From: Richard Castro-Parker
Sent: 06 March 2019 09:10
To: Planning.Responses
Subject: FW: Parsonage Farm House, Lake Lane, Barnham, PO22 0JD

Please could this e-mail be uploaded to as Conservation Officer's follow-up comments for application ref: BN/38/18/L

From: Martyn White
Sent: 26 February 2019 14:58
To: Richard Castro-Parker
Cc: Daniel Vick
Subject: RE: Parsonage Farm House, Lake Lane, Barnham, PO22 0JD

Mr & Mrs Miles
Oak Framed Annexe - 1:100 - Date: 01/02/19

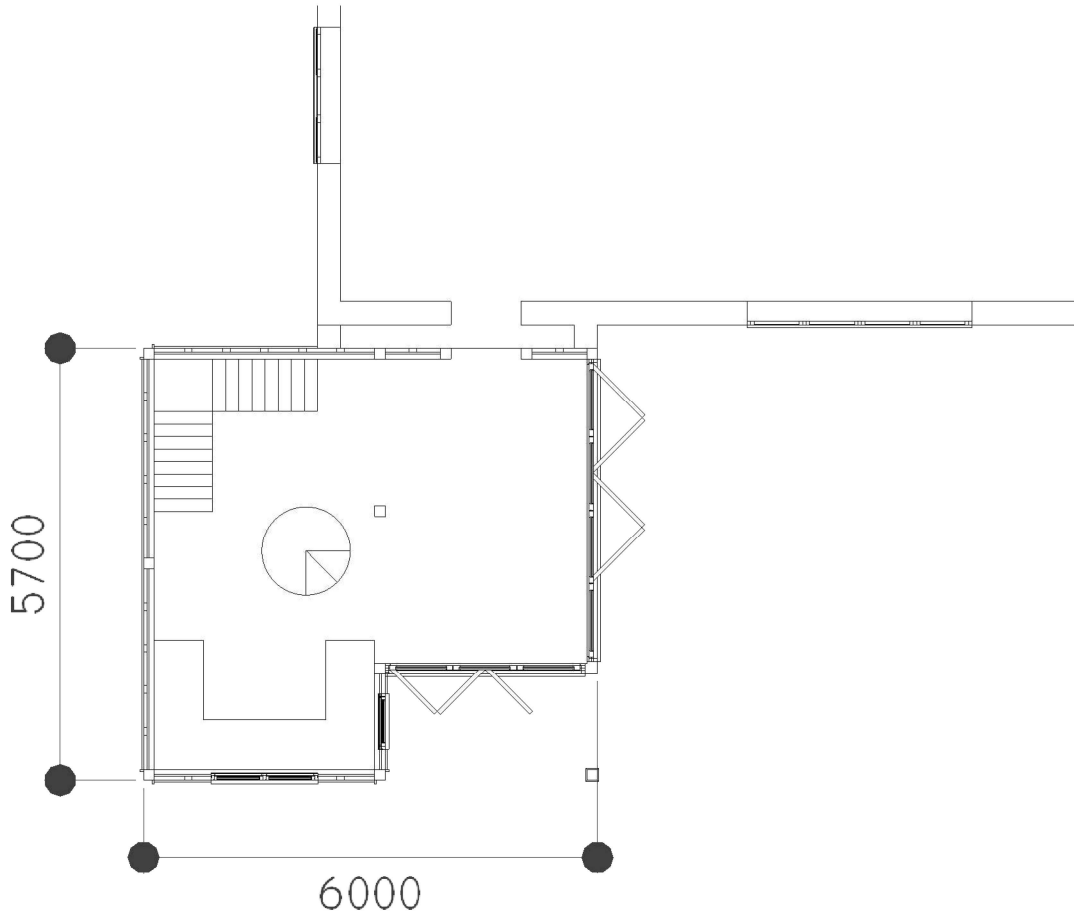
The proposed amendments appear so minor that it is not clear how the applicant/agent have taken my previous comments into account. Unfortunately, due to the very minor level of change, my previous comments still apply. These comments are linked to the listed building consent, but I can pass a copy of these to you again if that would help you?

Further to our recent exchange following the conservation officer comments, these have been duly noted and the design revised to lessen the overall height and reduce the projection past the end of the building.
